20th April 2009

The Town and Country Planning Act 1990 (as amended)

House & detached garage (Amendment to previously approved R/271/08).
8 Bushby Avenue Rustington

BLOCK PLAN Scale 1:500

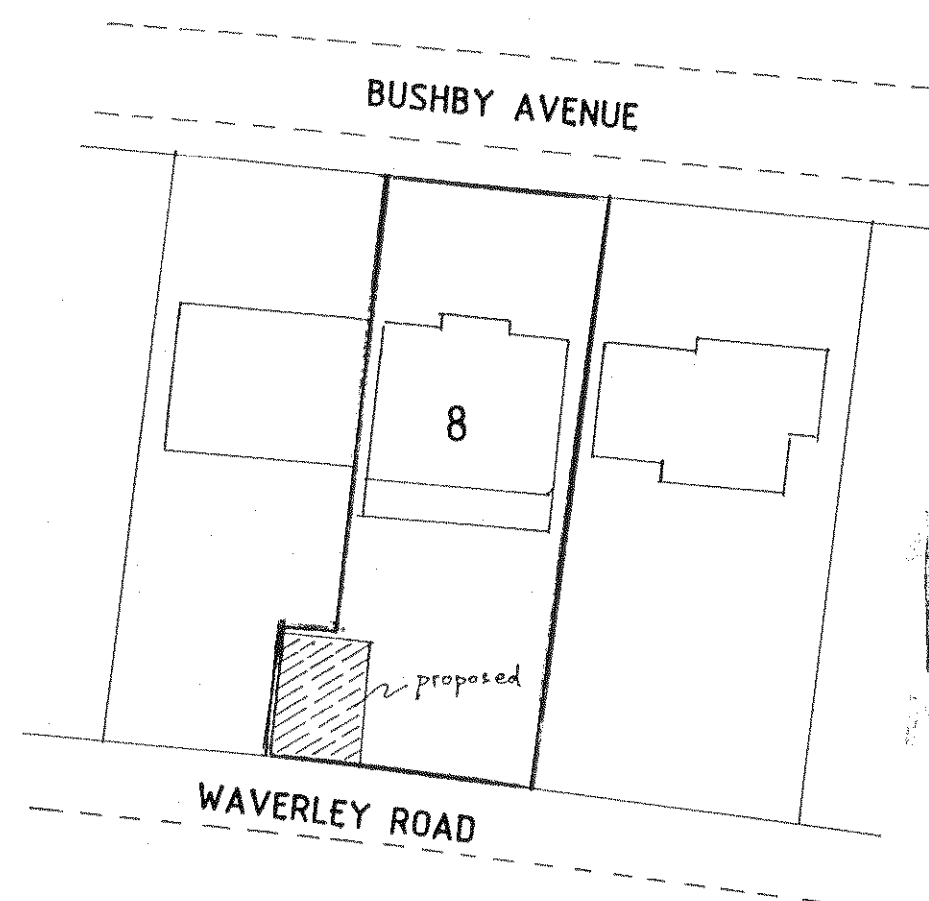
(i) In respect of the proposed garage, the formation and use of a vehicle access to the public highway at this point would add to the hazards of highway users to an unacceptable degree, and the introduction of a new vehicle access on a stretch of the road, namely Waverley Road, where no accesses of this type currently exist, would most certainly prove to be to the further detriment of highway users ☐

(ii) The proposal would, if approved, create a precedent which could result in more similar proposals in the vicinity, the cumulative effect of which would be to alter the character of the locality to the serious detriment of the amenities of the area. ☐
